SUSSEX COUNTY COUNCIL CONSULTATION

TO:	Arun District Council FAO: D <u>Johnson</u>
FROM:	WSSC - Highways Authority
DATE:	03 December 2019
LOCATION:	The Beach Hotel, former Mud Club & 2-4 Waterloo Square Bognor Regis <u>PO21 1SU</u>
SUBJECT:	BR/282/19 Redevelopment into 49 No apartments consisting of 24 No 1 & 25 No 2 bed apartments & 2 No commercial units (A3 Restaurant & Cafe). This application affects the character & appearance of The <u>Steyne</u> , Bognor Regis Conservation Area & may affect the setting of a listed building.
RECOMMENDATION:	More Information
S106 CONTRIBUTION TOTAL:	£ provided separately

Drawing Status	FINAL		
Client	B5 Ltd		
Project	Waterloo Square, Bognor Regis		
Drawing Title	Vehicle Swept Path Analysis		
Scale	As Shown	Date	Mar 2020
Drawn By	SMO	Checked By	ALB
Drawing No.	2020-6153-002		Rev.
		A

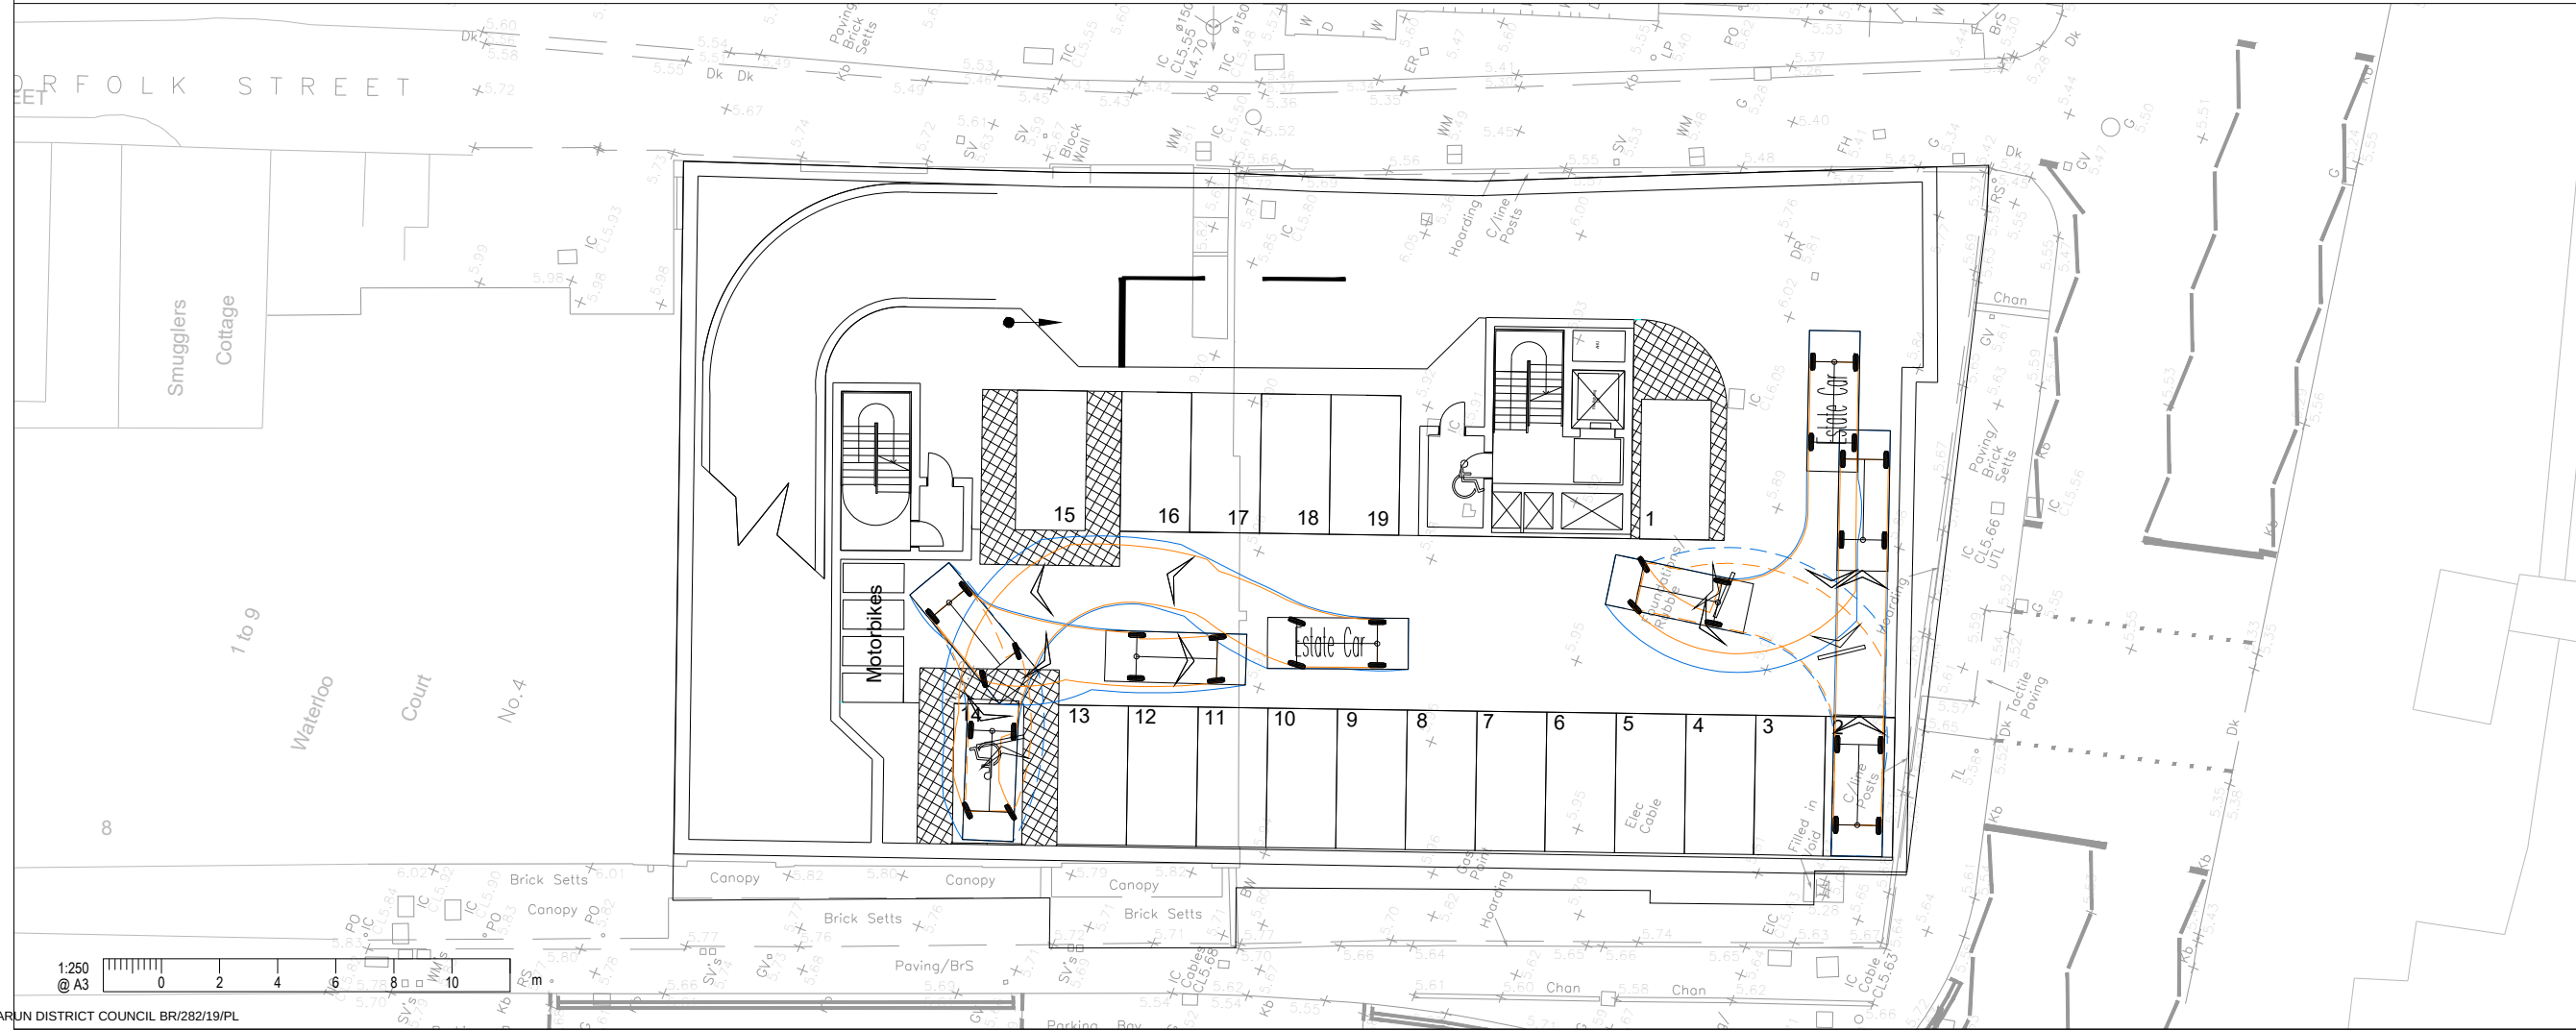
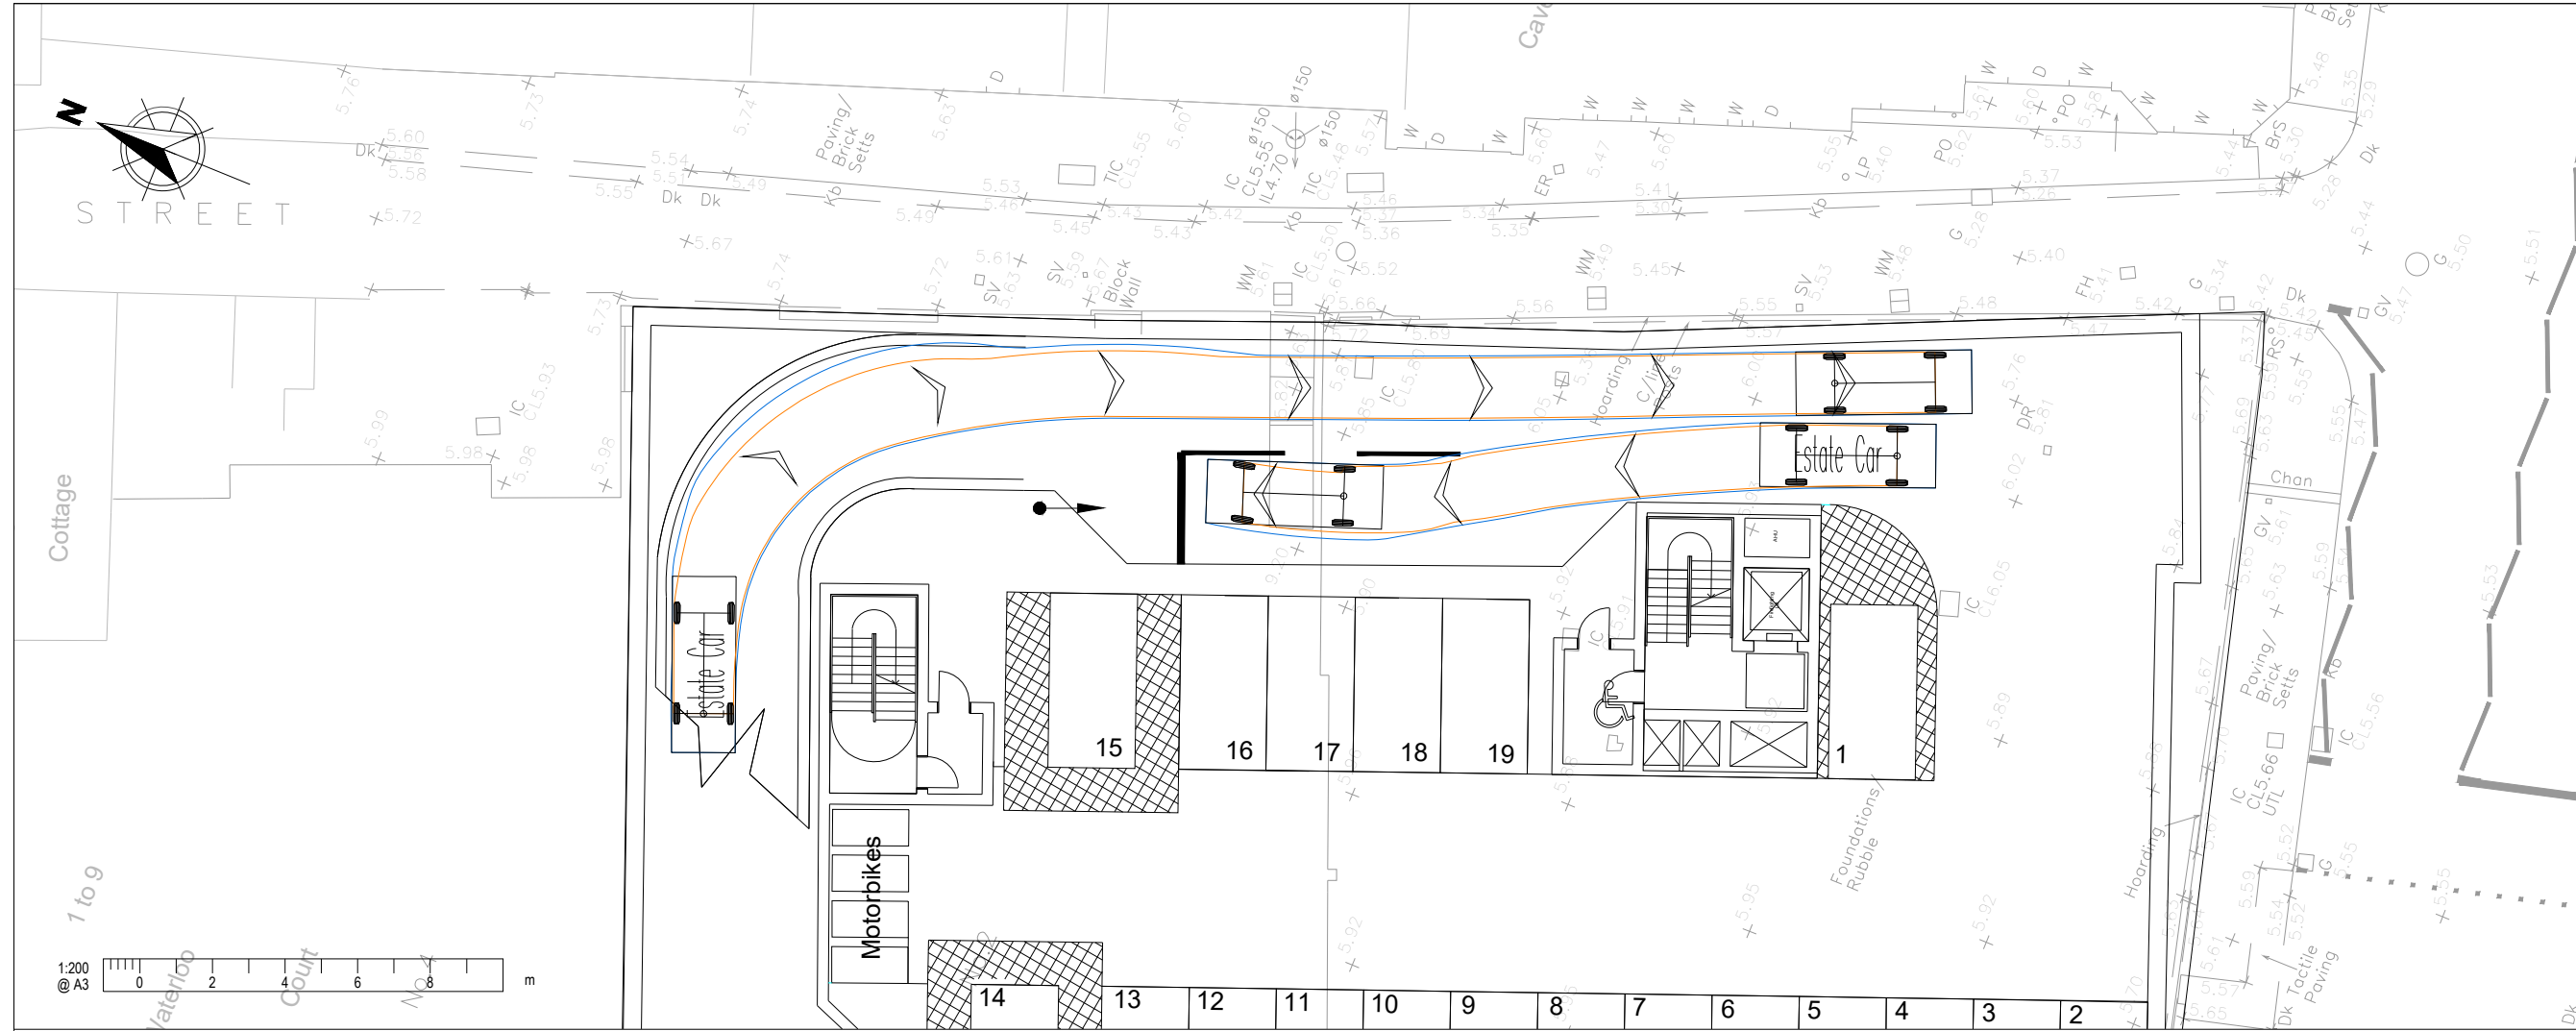
The access is not wide enough for two cars to pass however a waiting space just inside the site and internal car park traffic light system is proposed. The waiting spaces at the access would appear to result in a car overhanging the footway and waiting space just within the access has been provided on the right hand side where this should be on the left hand side. The applicant should clarify how the traffic light system will work and where possible priority should be given for vehicles entering the site. Full swept path tracking diagrams should be provided showing that a car can access from Waterloo

Square, including the parking corridor opposite, and manoeuvre within the basement parking level.

- Provide Stage One RSA and Designers Response in accordance with GG119
- Provide full swept path tracking plans to demonstrate workability of proposed access arrangements, showing a car entering and exiting from Waterloo Square, including parking corridor on western side of carriageway.
